Narromine Shire Council

Response to Submission of Environmental Impact Statement
State Significant Infrastructure
Inland Rail- Narromine to Narrabri SSI-9487

Figure A6.8 Narrromine to Cobar Line connection options

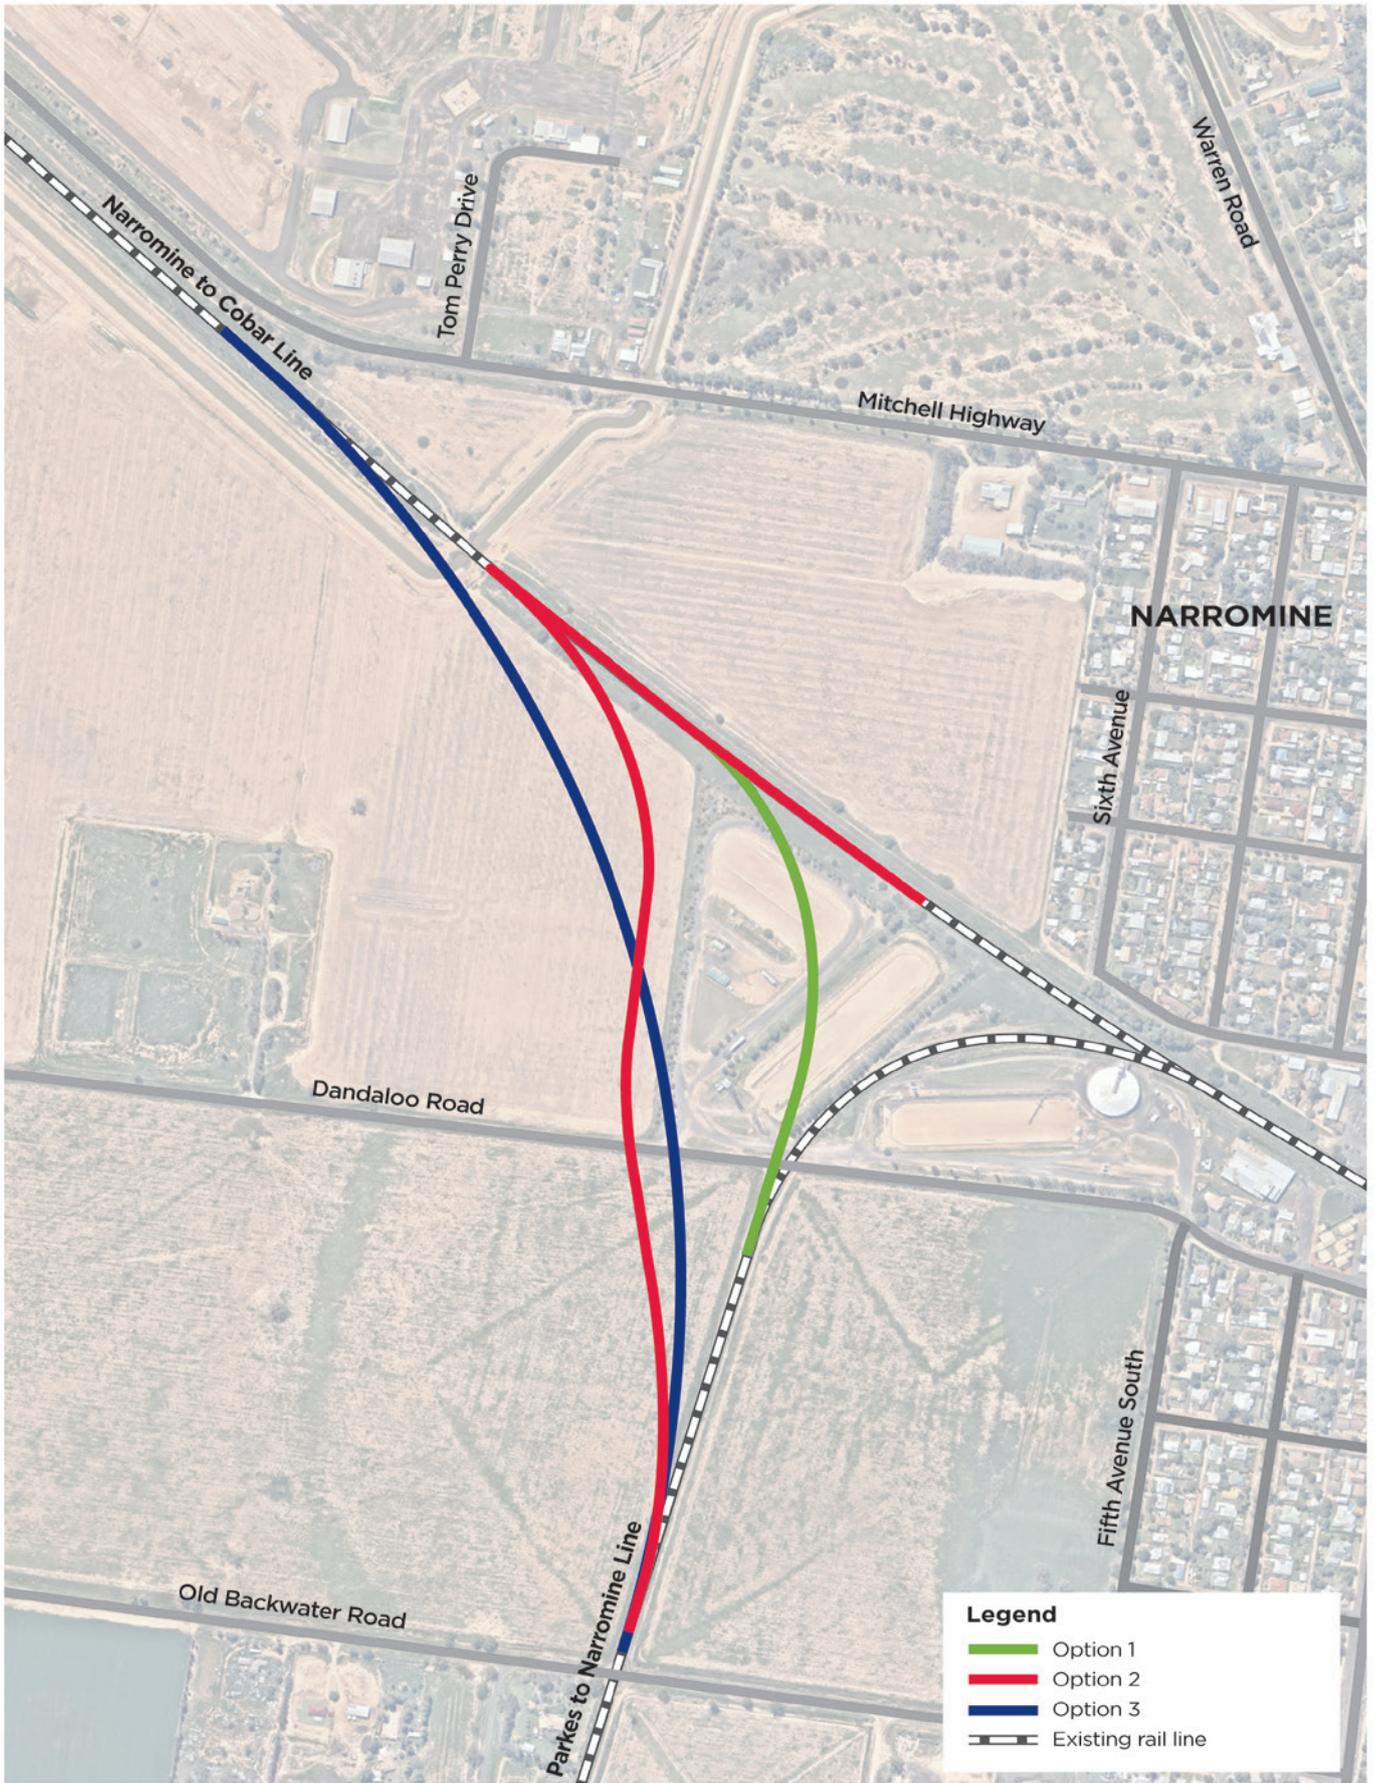
- Council requests the EIS demonstrate why the proposal has minimal connectivity to Inland Rail, particularly in high production agricultural areas where there is an opportunity for road freight movements to be shifted to rail.

Figure B3.3 **Predicted flooding extents**
- operation (one per cent AEP event) (map 1)

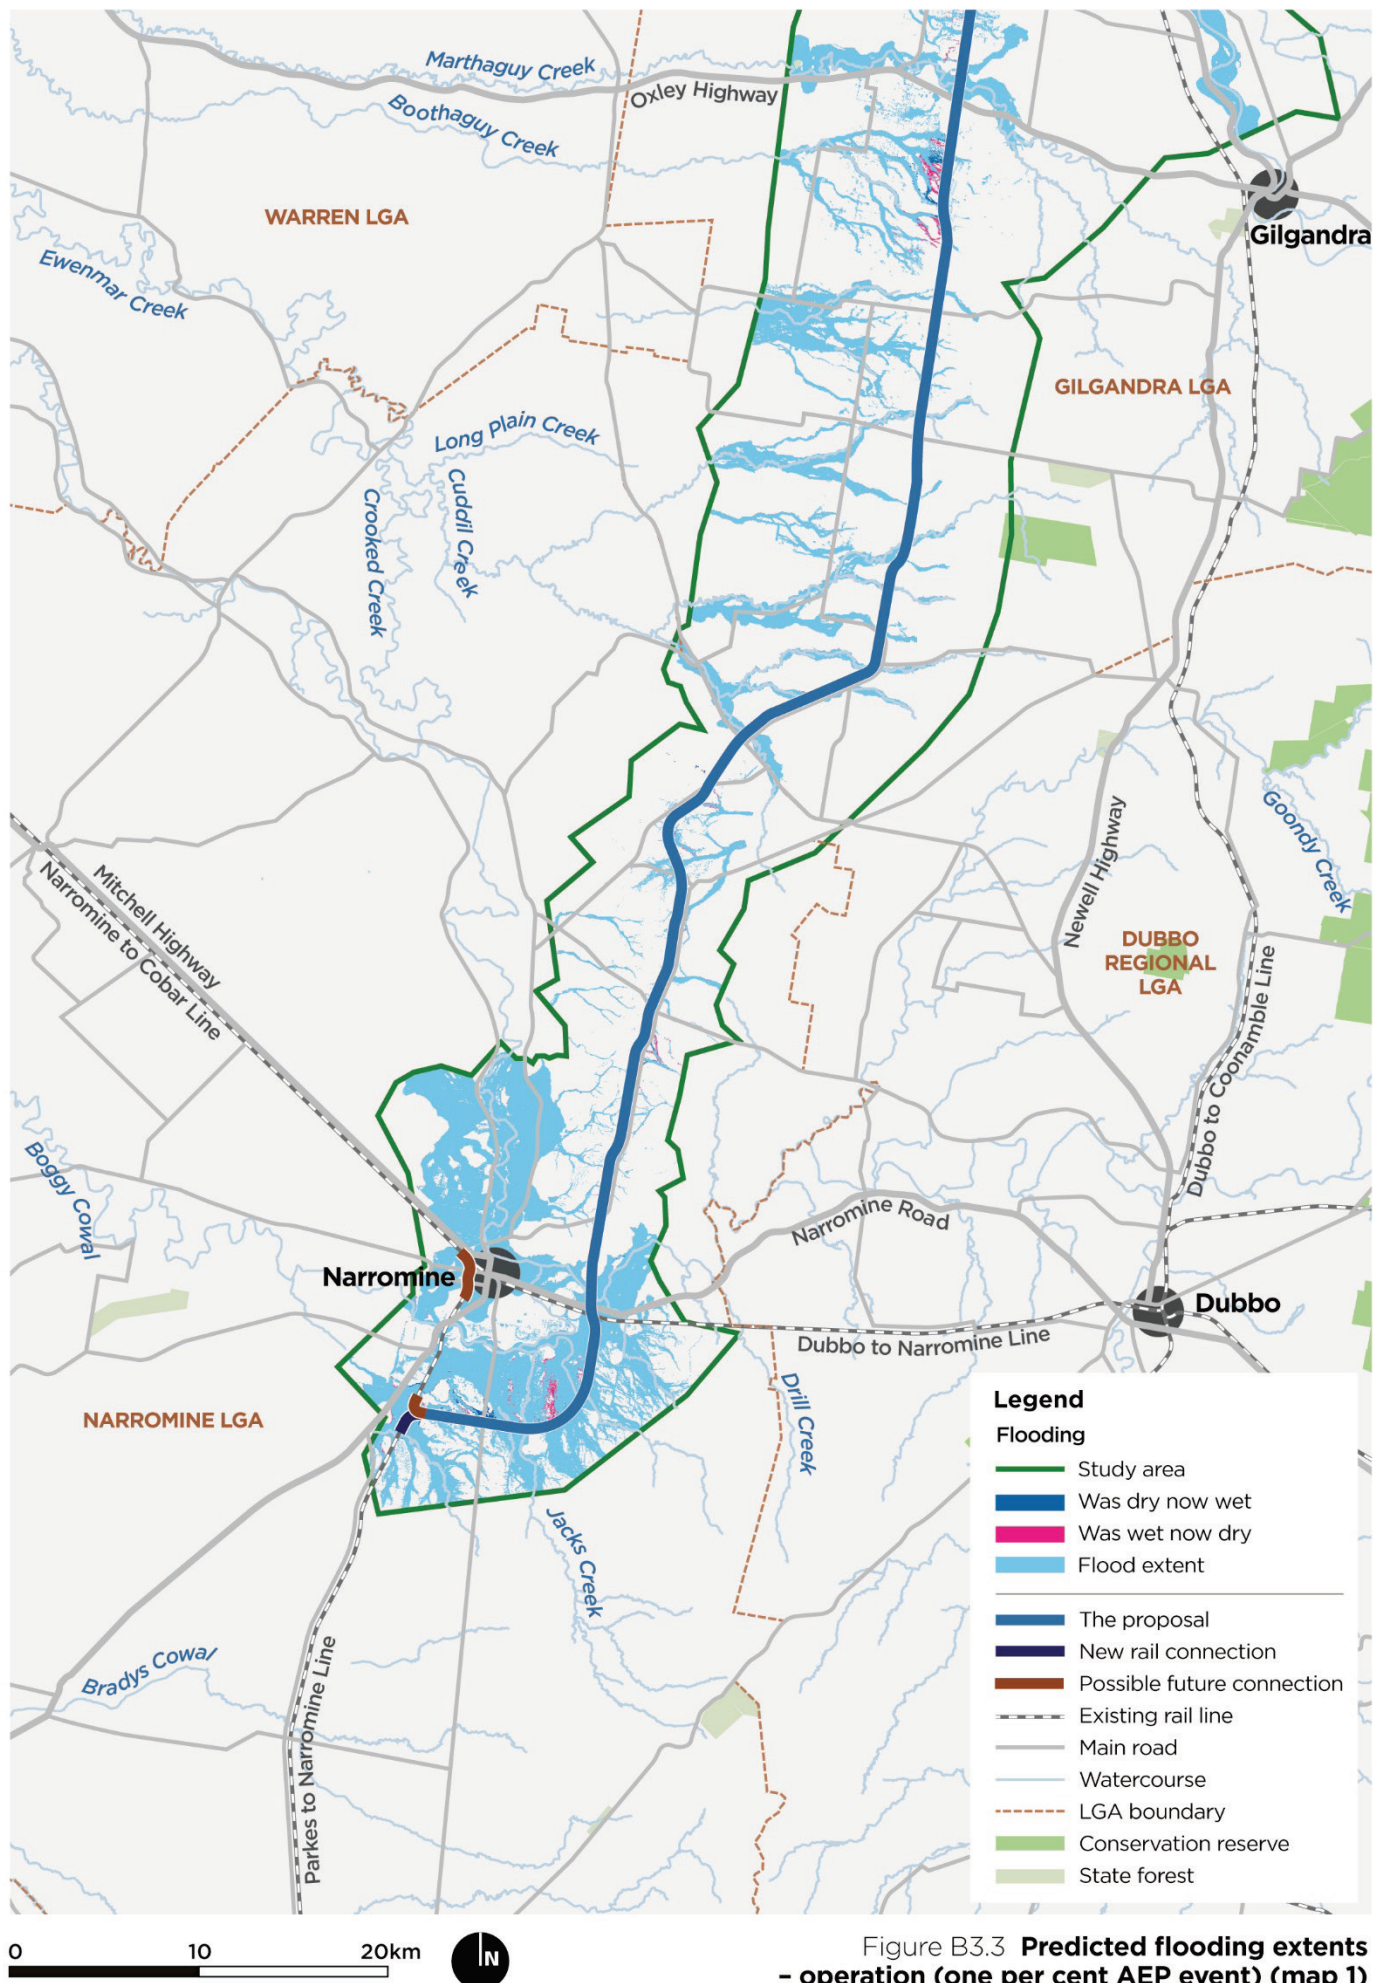
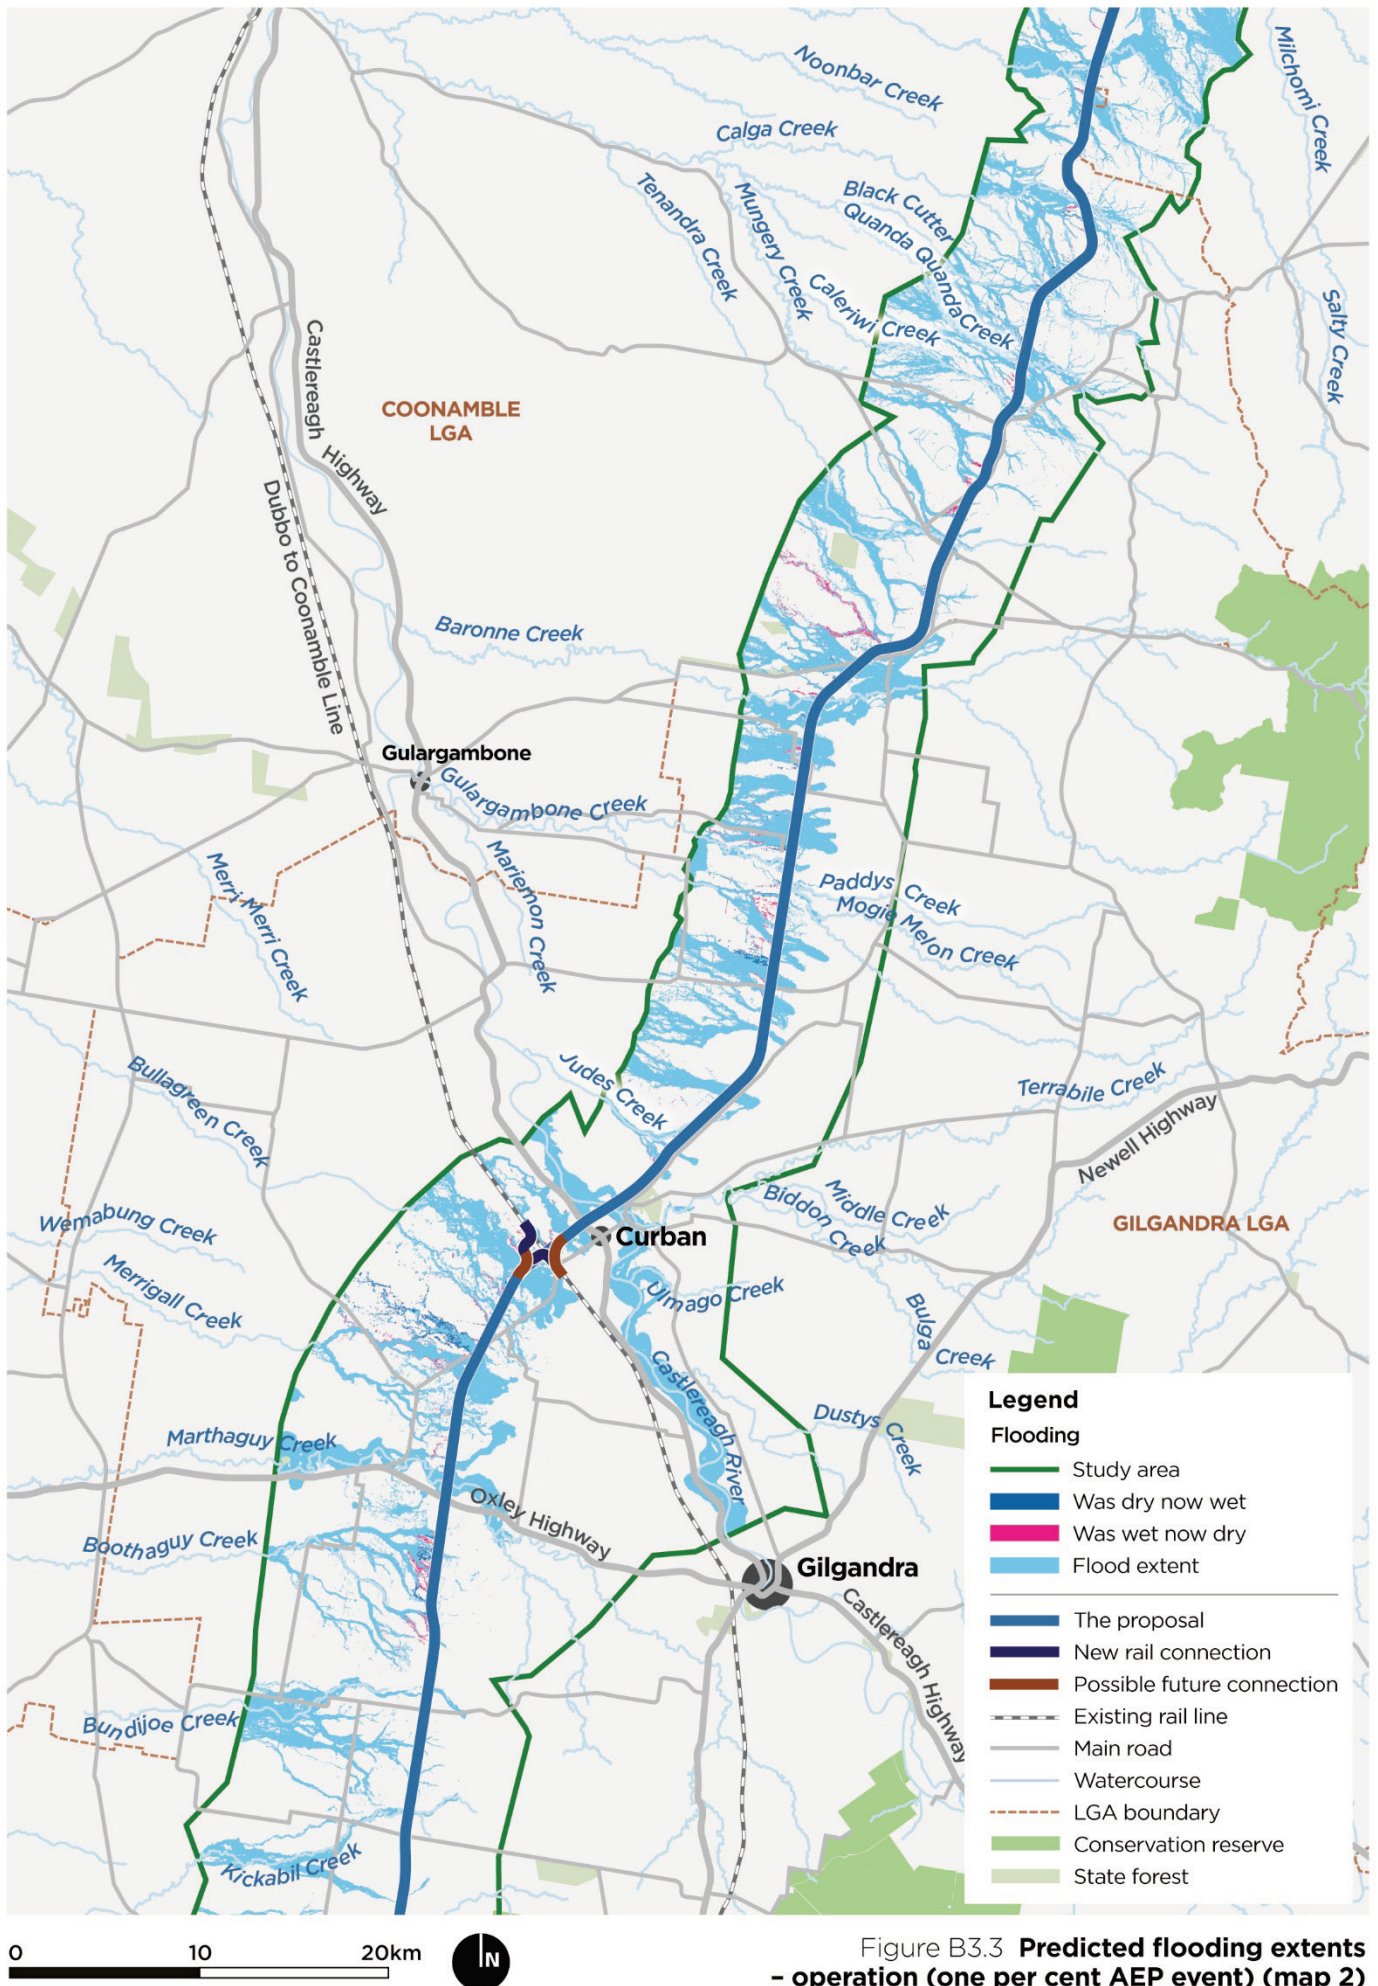
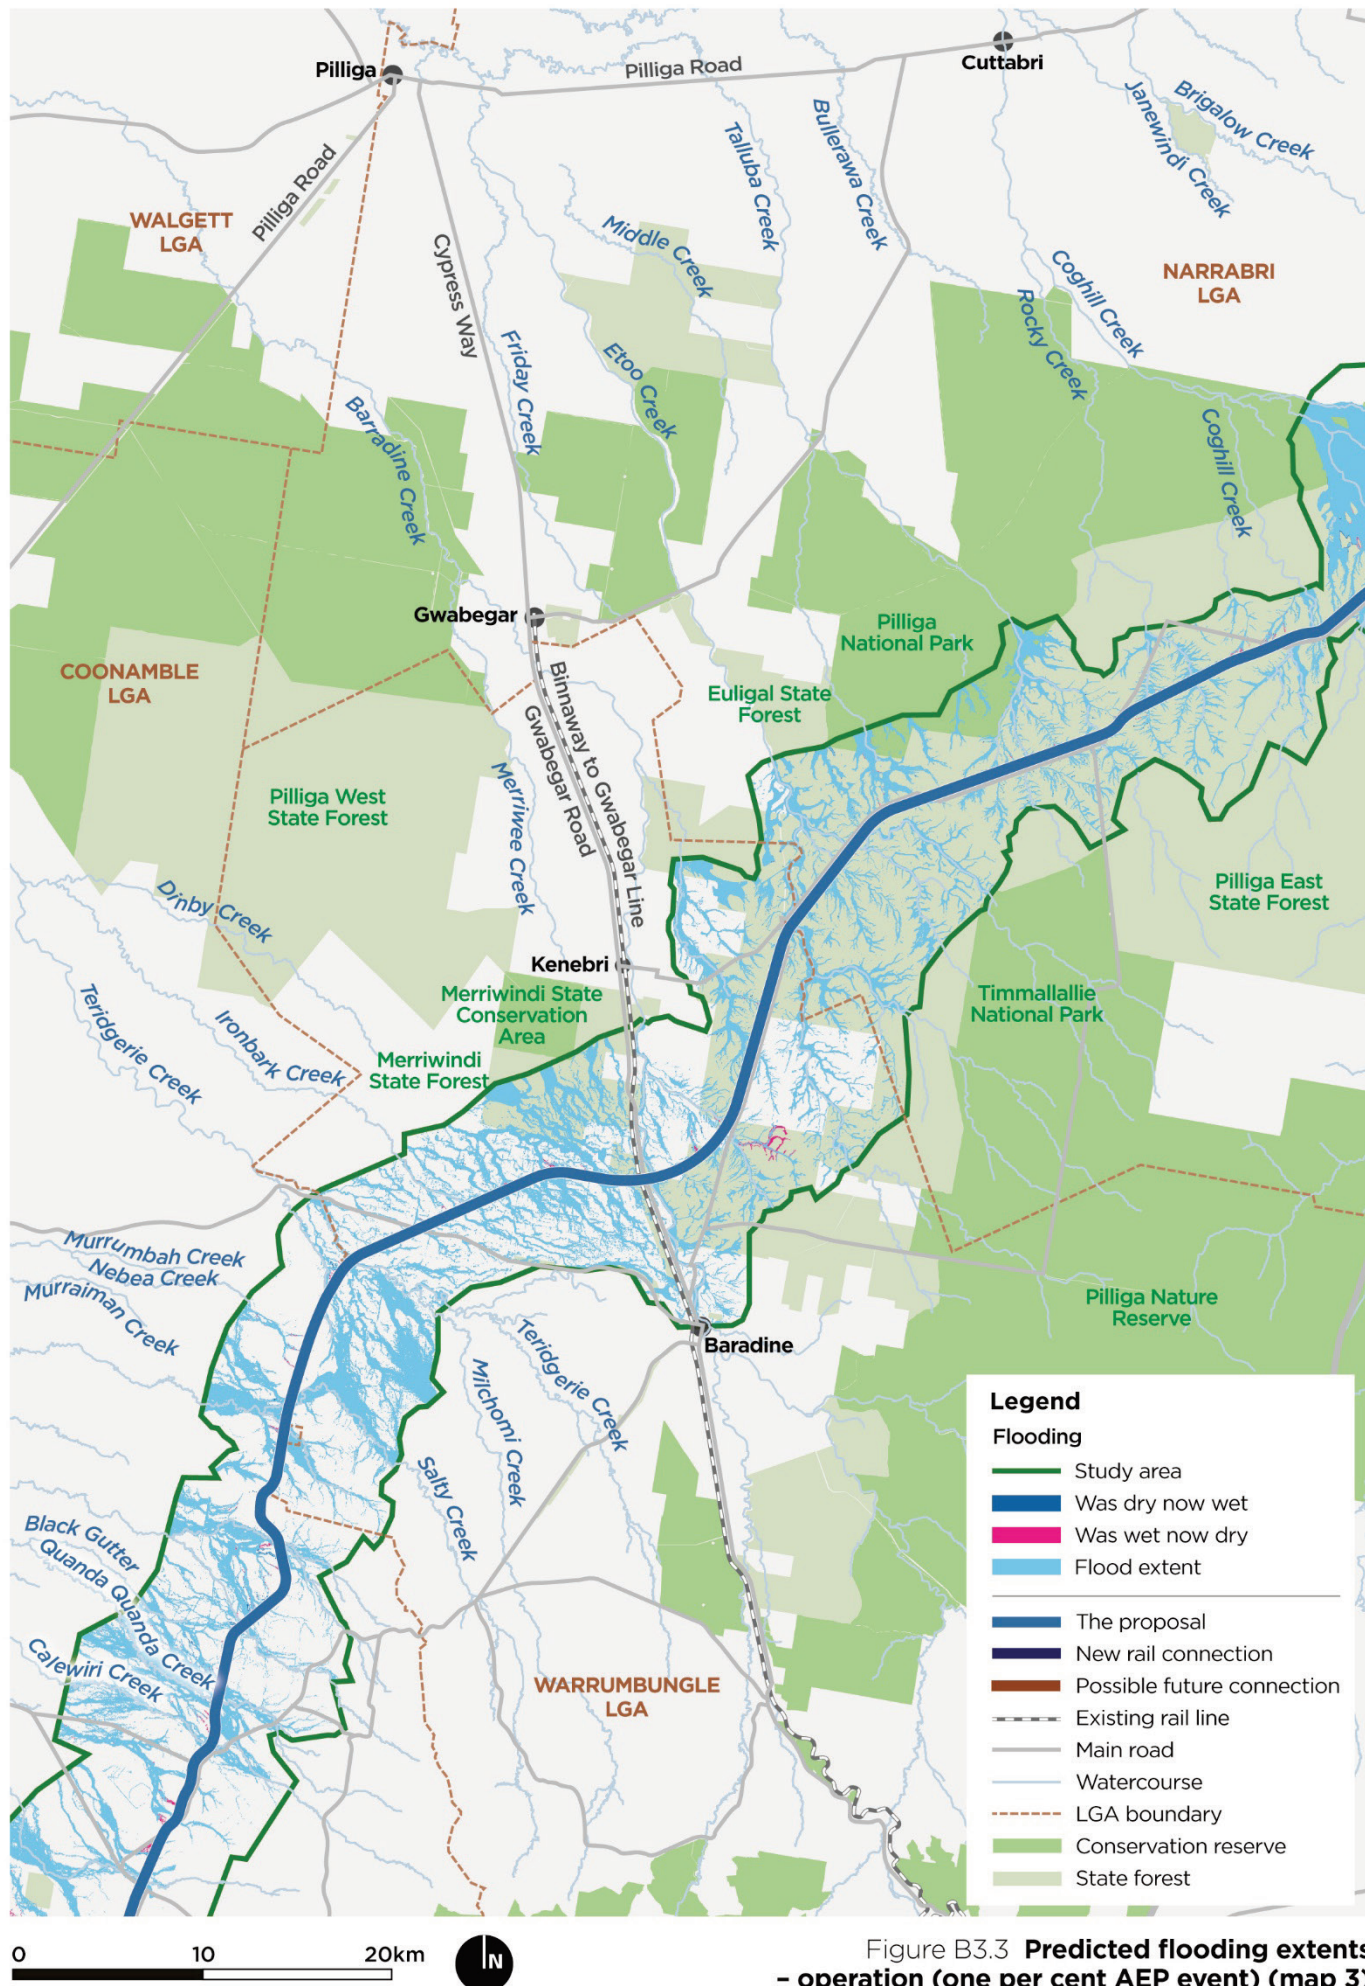
- Council expects more detailed flood assessment to be undertaken during detailed design to ensure flooding where the new rail line joins the old Narromine-Parkes rail line, including the area near Narwonah Siding, is well understood and managed accordingly.
- Council expects further detailed discussion and consideration of the future development of a town levee bank at Narromine aimed at protecting the township from flooding. Flood modelling at the detailed design stage must be undertaken in consideration of advice from Department of Planning, Industry and Environment.
